Date: 21-Jan-2025  
Our Ref: 2024/93340

**TOWN AND COUNTRY PLANNING ACT 1990  
TOWN AND COUNTRY PLANNING (GENERAL PERMITTED DEVELOPMENT) (ENGLAND)  
ORDER 2015 – SCHEDULE 2, PART 1, CLASS A.1 (g)  
AT: 43, Oak Road, Bradley, Huddersfield, HD2 1SN  
The proposal is for erection of single storey rear extension. The extension pro**

The proposal is for erection of single storey rear extension. The extension projects 5m beyond the rear wall of the original dwellinghouse. The maximum height of the extension is 3.0m, the height of the eaves of the extension is 2.65m

Proposed Plan Scale 1:100

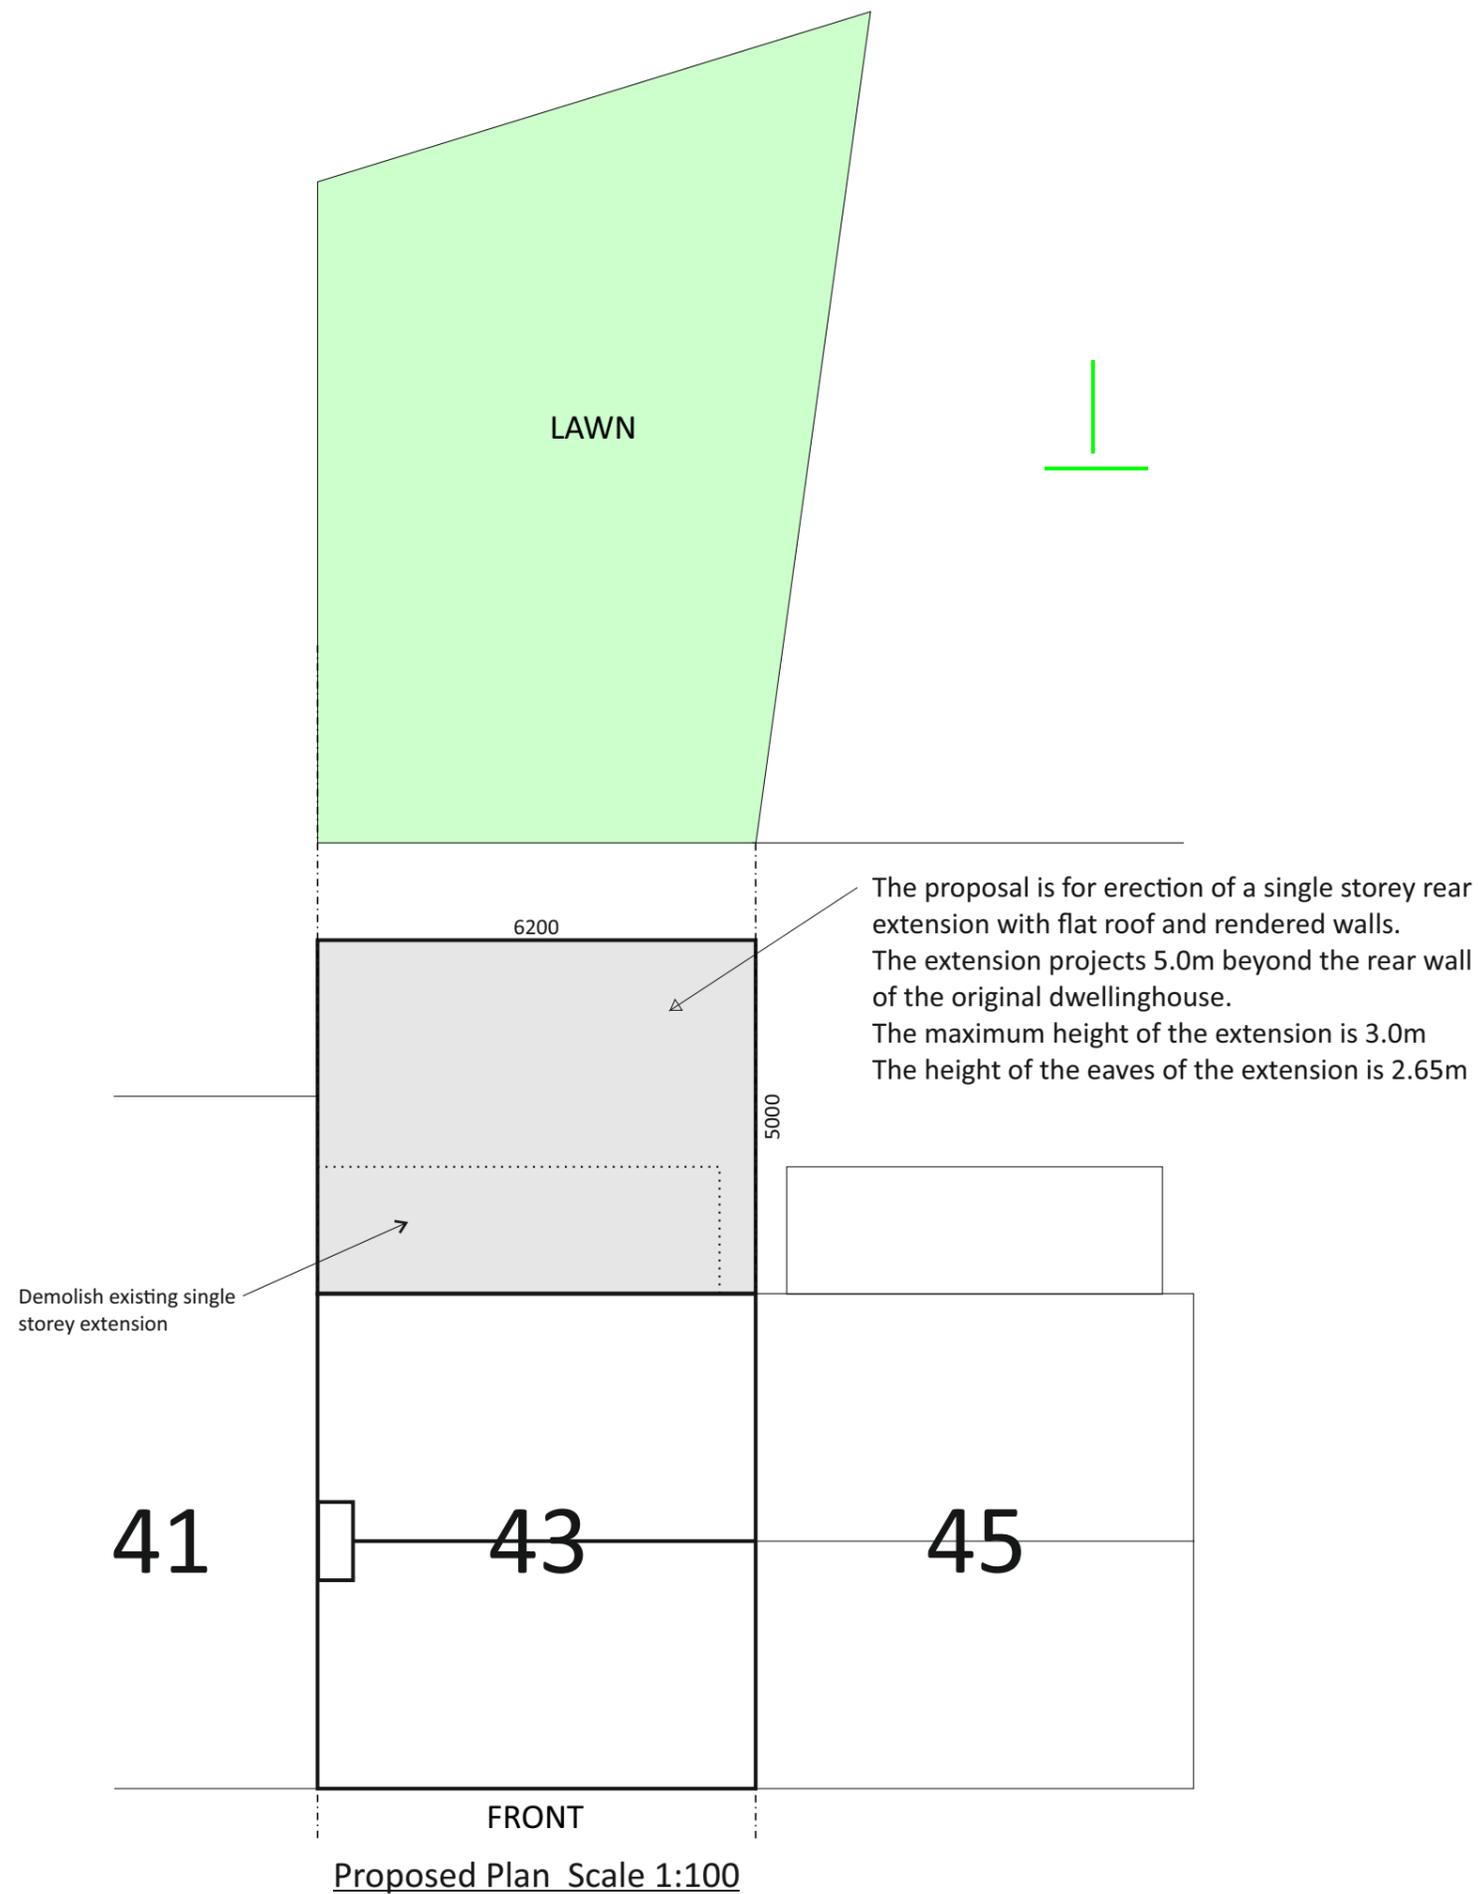
It is considered the proposed development cannot benefit from a general planning permission under Article 3(1) and Schedule 2, Part 1, Class A of the Town and Country Planning (General Permitted Development)(England) Order 2015 (as amended) as the proposed extension would extend beyond a side elevation of the original dwellinghouse and be more than half the width of the original dwellinghouse contrary to sub-paragraph A.1(j) of Class A.

The proposed rendered walls as indicated on drawing reference HD33UB15-v1 and as stated within the application form are considered to be contrary to condition A.3(a) of Class A which requires the material used on any exterior work must be of a similar appearance to those used in the construction of the exterior of the existing dwellinghouse.
